**From:** Lisa Jackson [redacted]  
**Sent:** 01 August 2019 15:15  
**To:** Simon Davis <Simon.Davis@arun.gov.uk>  
**Cc:** Andrew Tice [redacted] Spencer Bryan [redacted]  
**Subject:** Re: Yapton Crem App

I attach copies of emails between our transport consultant and the highway authority in relation to your request to consider restricting right hand turns to the A259 from Grevatt's Lane West.

In relation to physical measures to prevent right turns from the Crematorium I attach a screenshot extract of Plan 128.001.007 Rev C which forms part of the application submission -this is in Appendix D to the revised Transport Statement. This shows the kerb build up that would deter a right turn. The bollard could only be installed following a TRO if it was deemed necessary by the highway authority. We are looking at whether this design can be augmented with road signing. We will have more detail by Friday as requested.

PBA drawing 128.001.007 Rev D

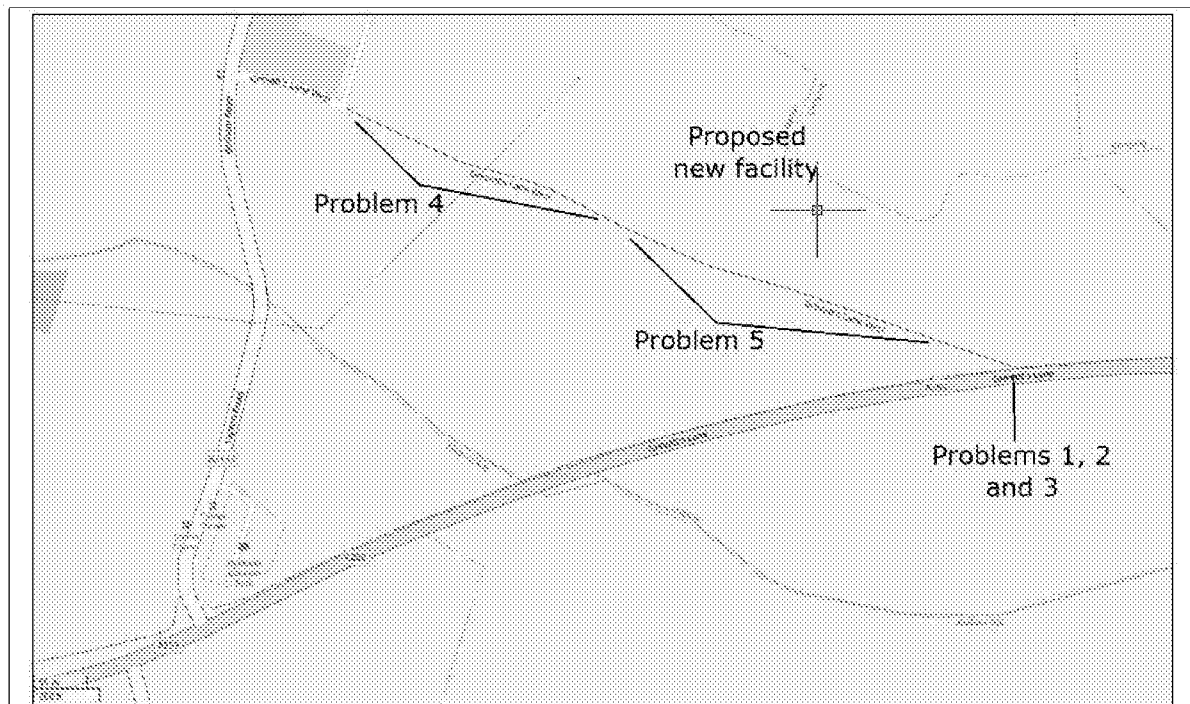
Asking the applicant to look at ways to amend the A259 junction design to deter right turns

Asking the applicant to incorporate surface materials/line painting or something similar on the Grevatt's Lane entrance to guide visitors to the A259 and not to turn right

I can confirm that the information supplied shows that current proposals provide a suitable access for the development. From WSCC highways point of view a banned right turn is not necessary to make the development acceptable.

The bullet points below summarise the points of our discussion as to why a banned right hand turn out of the site is not considered a suitable access arrangement. Alternative access arrangements were considered at a pre application stage (to which my response is included with your transport statement) This indicated that the most suitable arrangements would all include a right hand turn out on to the A259.
